**KIRKLEES METROPOLITAN COUNCIL
INVESTMENT & REGENERATION SERVICE**

DELEGATED DECISION TO DETERMINE PLANNING APPLICATIONS

| Reference No: | 2023/62/90154/W |
| Site Address: | 3, Victoria Springs, Holmfirth, HD9 2NB |

| Proposed Loft Conversion |                |          |

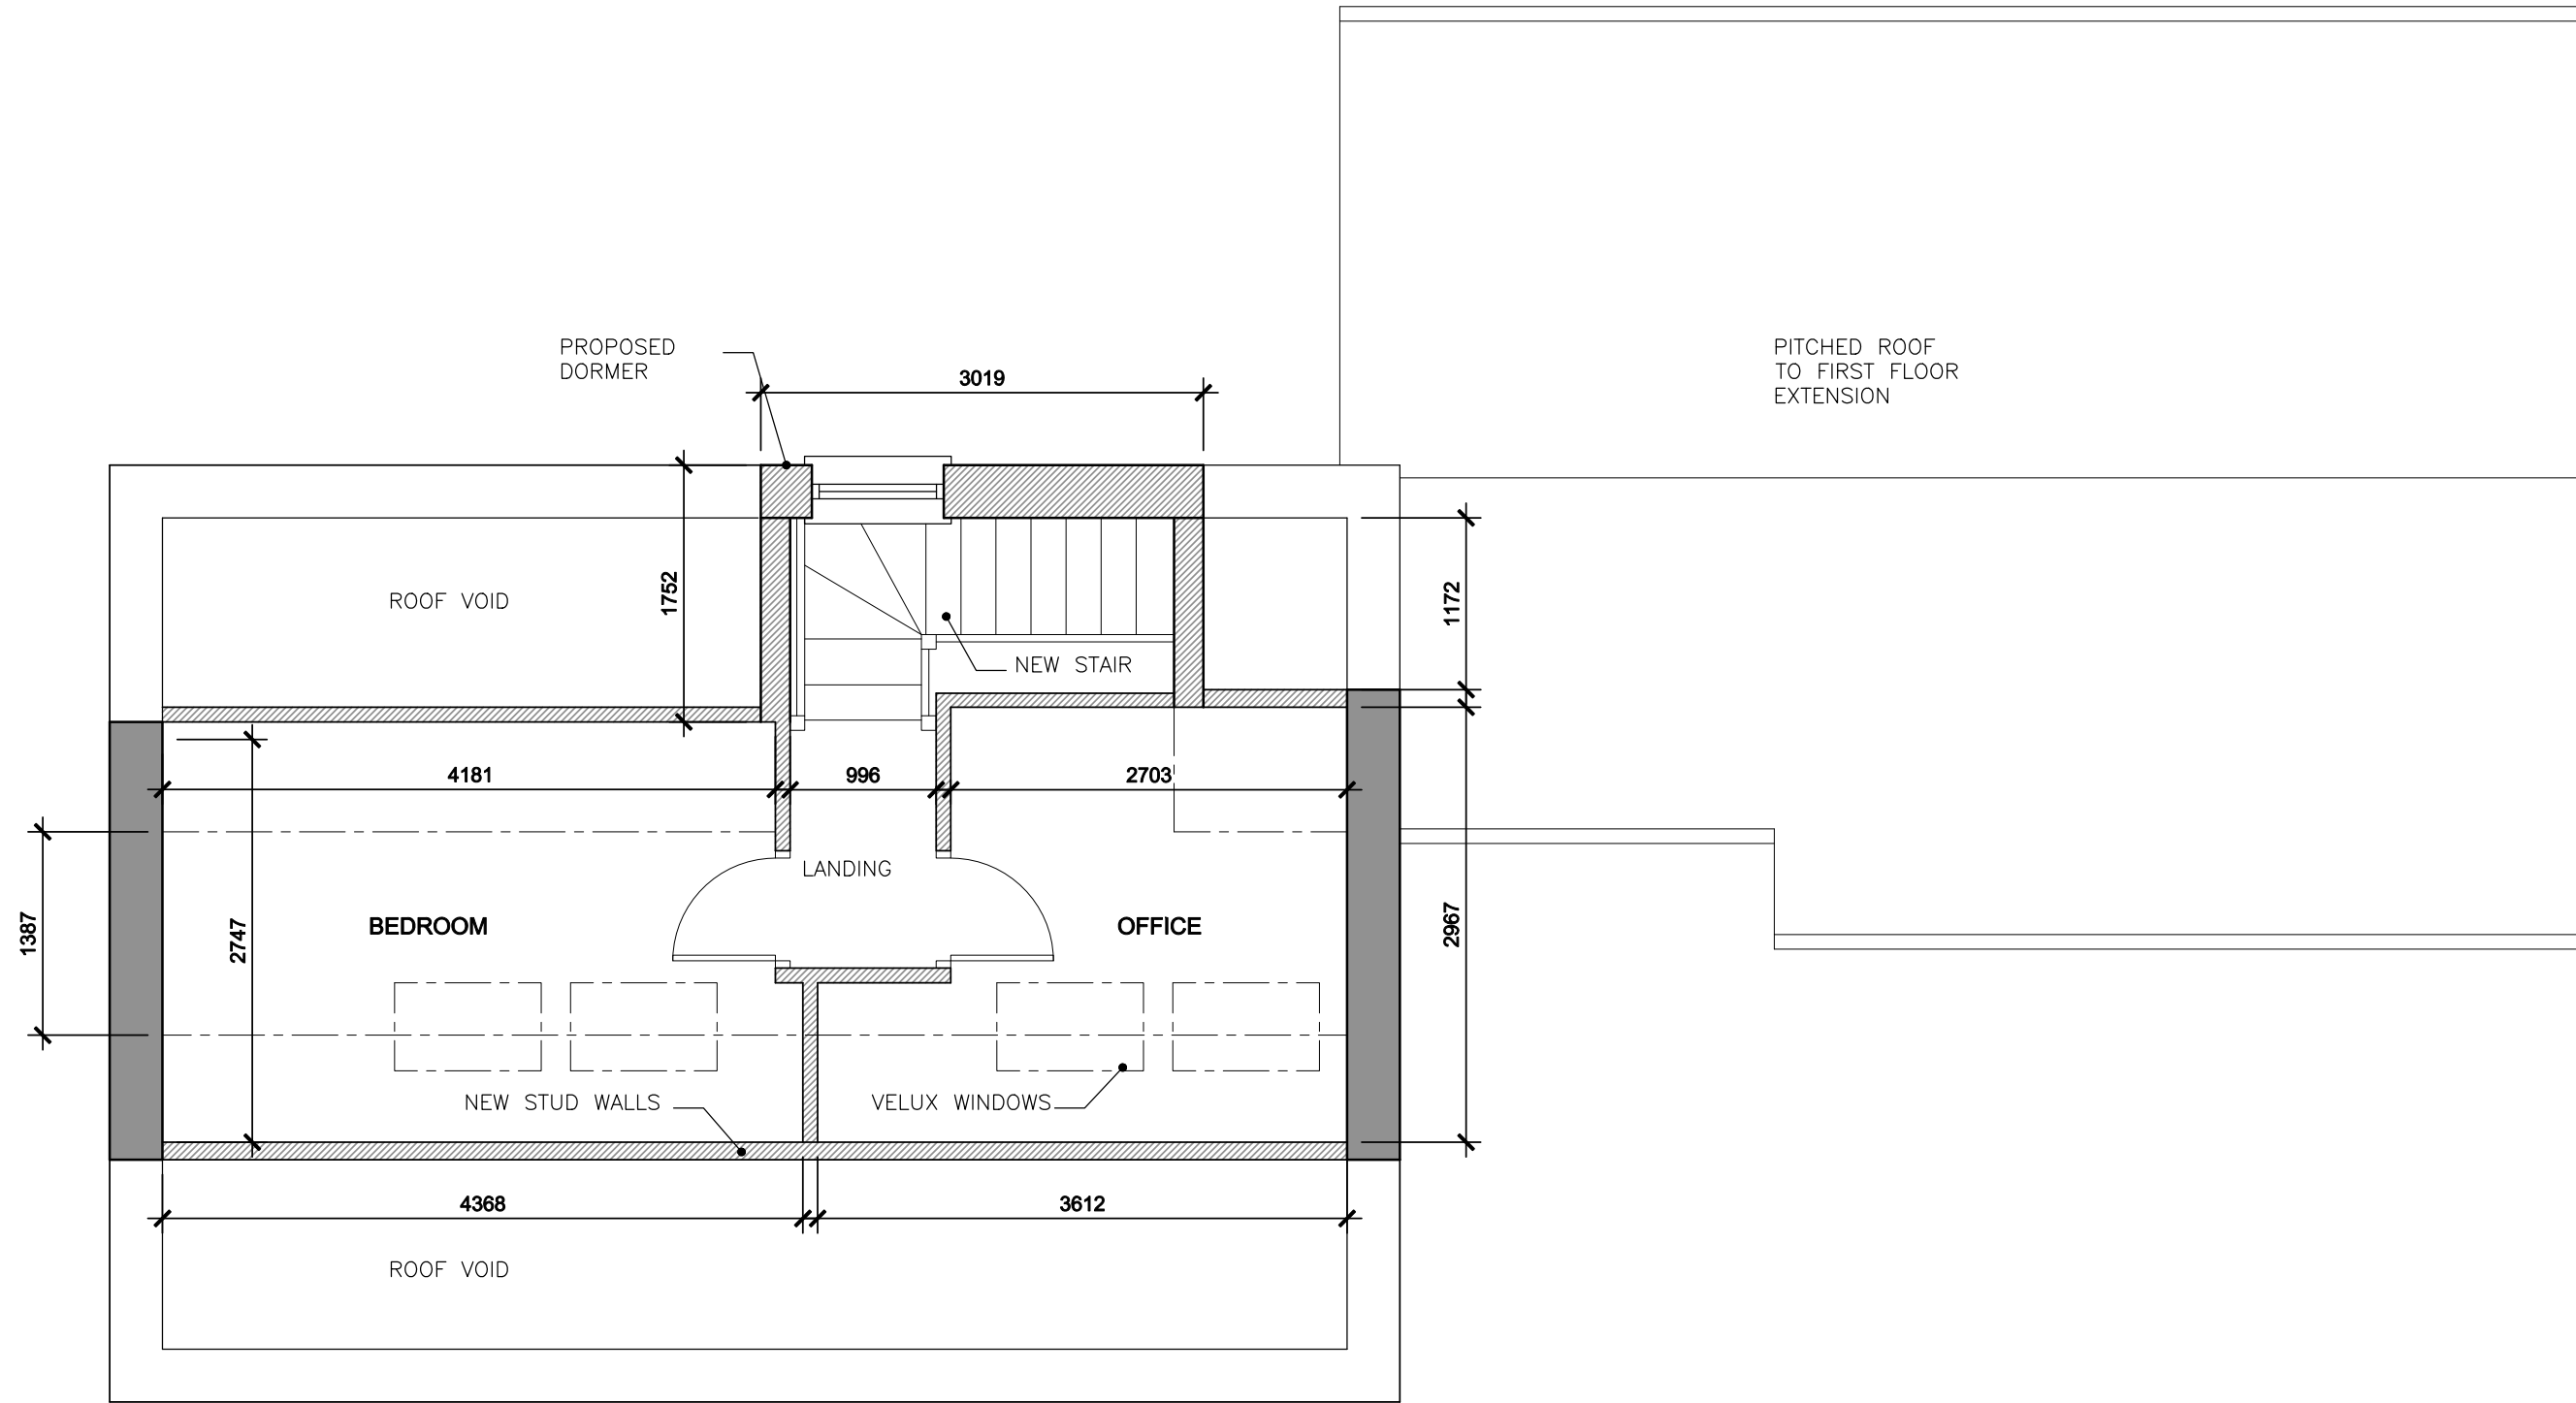
It is proposed that internally, the property would be reconfigured and also a loft conversion is proposed to provide additional accommodation. There are also roof lights proposed within the north-elevation roof slope and south facing elevation roof slope and the garage door would be reduced from a double to a

single door. There are also windows proposed within the second floor of the property within the gable ends of the west and east facing elevations.

The proposed works would comprise of a first floor extension over the existing garage and a dormer within the south facing elevation. There are also proposed internal works to reconfigure the internal accommodation at ground floor level, first floor level and within the roof space however these works do not require planning permission. Alterations are also proposed to for additional openings within the roof space and within the existing elevations and roof slopes.
